From: Mark ABMH [REDACTED]
Sent: 27 June 2017 15:01
To: Paul Cann
Cc: Anita Gardner; 'Paul Cleare'; ben.hatt@planningissues.co.uk; 'John Whittle'
Subject: RE: East St/Fitzalan Rd, Littlehampton - Ref. LU/173/16/PL - Surface Water Drainage
Importance: High

From: John Whittle [REDACTED]
Sent: 21 June 2017 12:05
To: Paul Cann
Cc: Anita Gardner; Paul Cleare; [REDACTED] Crossfield Consulting
Subject: East St/Fitzalan Rd, Littlehampton - Ref. LU/173/16/PL - Surface Water Drainage

Proposed Development at East St/Fitzalan Rd, Littlehampton
Planning Ref. LU/127/17/DOC
Planning Application Ref. LU/173/16/PL

FIGURE S-3

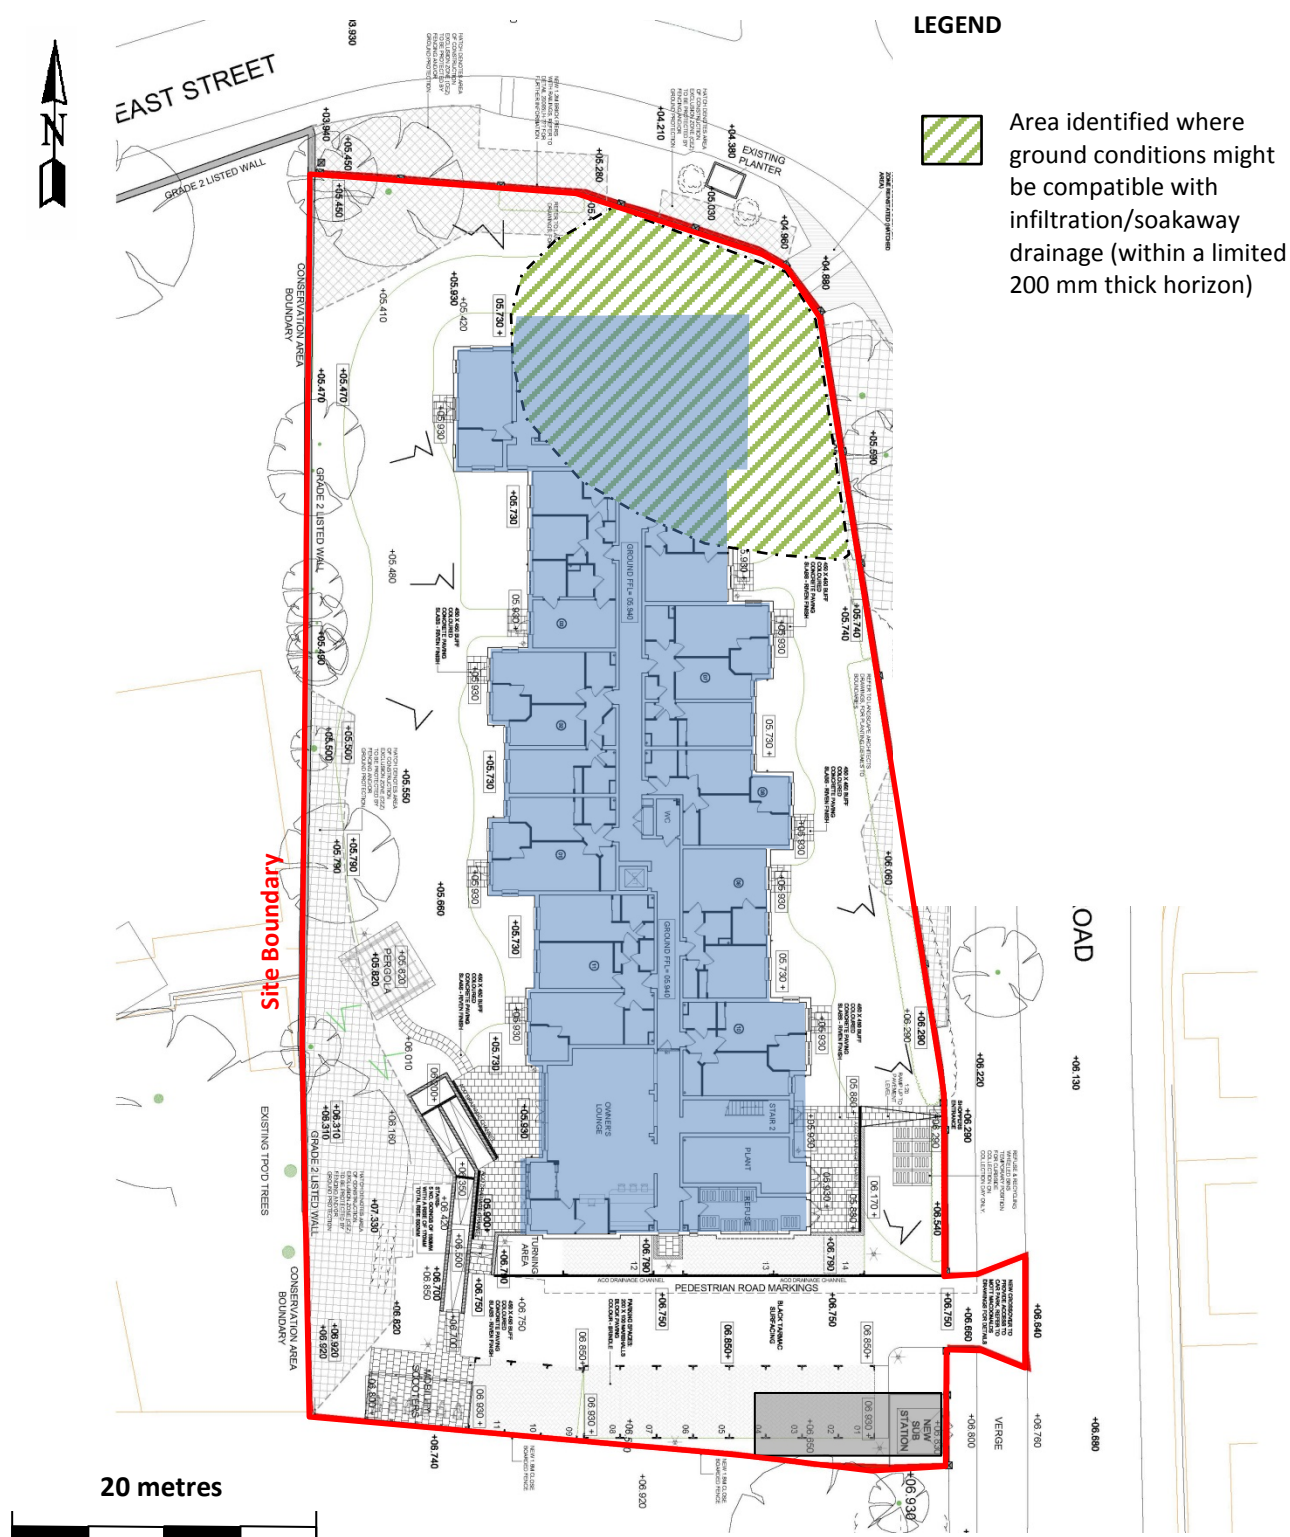
As shown in our Figure S-3, only a very limited area of the site is provided where chalk strata are present above the characteristic groundwater level and where the 200 mm thick infiltration zone is provided. Such a limited volume of suitable strata is considered not to provide a reliable soakaway solution over the design life of the proposed development.

It is noted that most of this area lies directly below the proposed building and within the designated tree protection zones; none of this area of suitable strata is more than 5 m from the proposed building foundations.

As apparent from the above issues relating to ground conditions (and with reference to Figure S-3), the use of soakaways is effectively precluded.
